**RE: Grading and Drainage Plan For Los Tres Hermanos (K11-D66) Dated
January 20, 2003**

**RE: Los Tres Hermanos Drainage Report (K11-D66)
Engineer's Stamp Dated November 11, 2002**

***LOS TRES HERMANOS &
52ND STREET & CRESTVIEW DRIVES***

ENGINEER'S SEAL	CRESTVIEW AND GONZALES	DRAWN BY JDN
	GRADING AND DRAINAGE PLAN	DATE 01-20-03
	TIERRA WEST, LLC 8509 JEFFERSON NE ALBUQUERQUE, NEW MEXICO 87113 (505)858-3100	21117GR31A.DWG
RONALD R. BOHANNON P.E. #7868		SHEET # 2 OF 12
		JOB # 21117

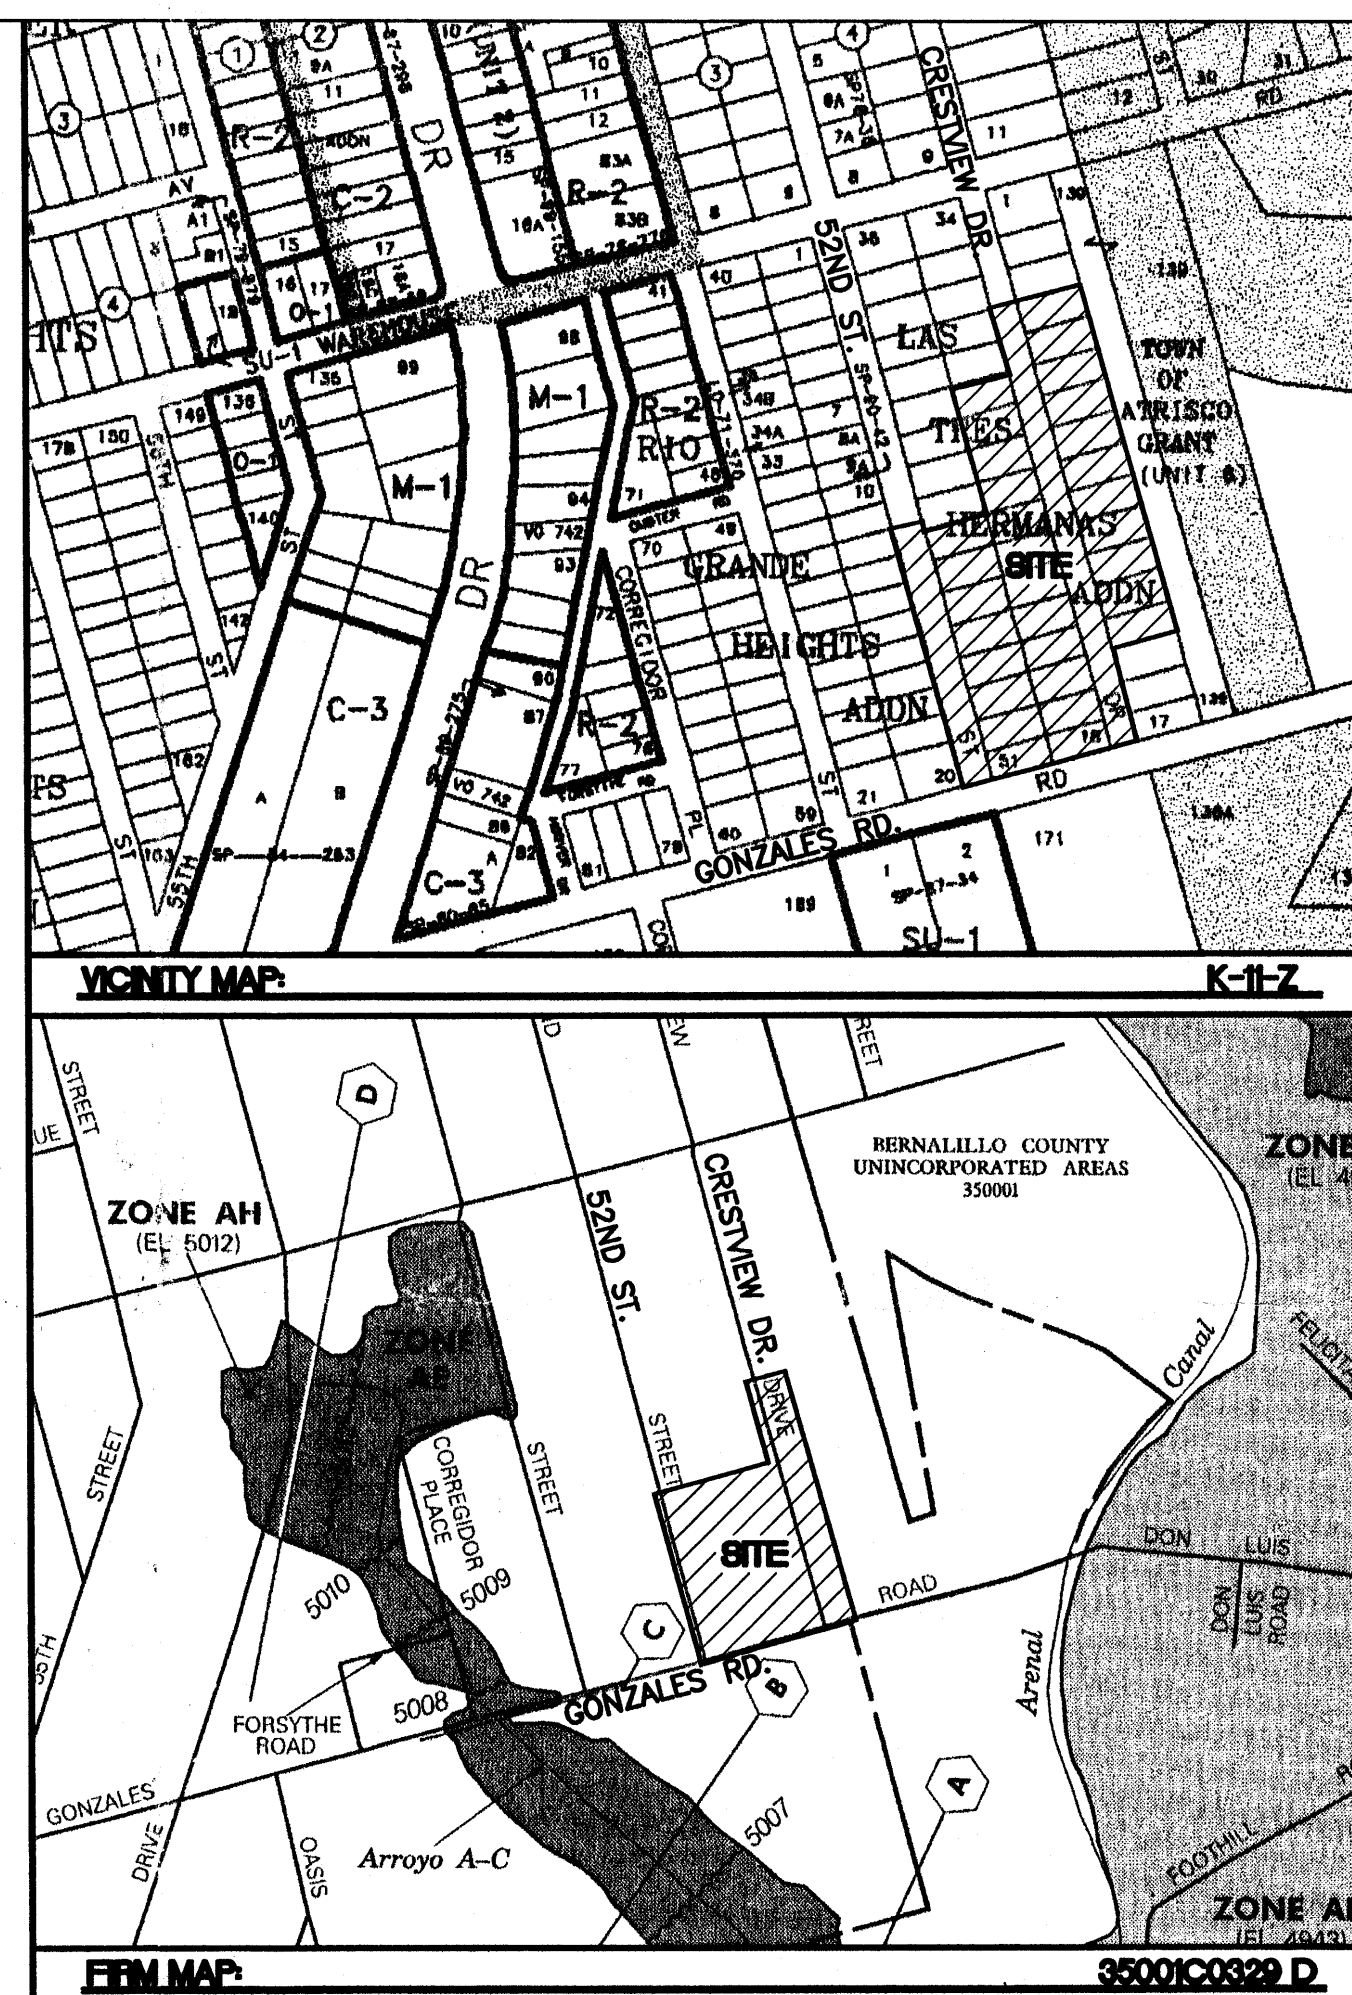
1. At the north boundary of Crestview you indicate that you are connecting to existing curb and gutter. A field visit showed that this is incorrect. Please correct this statement.
The new connection point on Crestview is shown on sheet 4 of 12 in the DRC Drawings.

2. Curb and gutter is going to have to be built from Gonzales to Churchill on Crestview.
The new curb and gutter is shown on sheet 4 of 12 in the DRC Drawings.

3. Please show a street profile from Gonzales to Churchill on Crestview. Use this profile to determine capacity of 100-year storm street runoff.
The plan and profile from Crestview is shown on sheet 4 of 12 in the DRC Drawings and the storm runoff was recalculated and shown in the revised Drainage Report.

4. The last existing lot (307 Crestview SW shown on Crestview on the west side is low compared to the street grades. Please show existing lot grades and compare them with the street grades.
As shown on sheet 4 of 12 in the DRC Drawings, all of the driveways are compatible with the new street grades except for Lot 32. The driveway for Lot 32 will have to be raised to match the new street grades. The finished floor of the existing house will allow for the adjustment of the driveway.

5. A site visit showed that the inlets at Crestview and Churchill do not collect the runoff from the new development. New inlets will be required at this intersection.
Crestview Drive was redesigned to create a sump area on the north end of the street and new inlets are to be constructed. These improvements are shown on sheet 10 of 12 in the DRC Drawings.
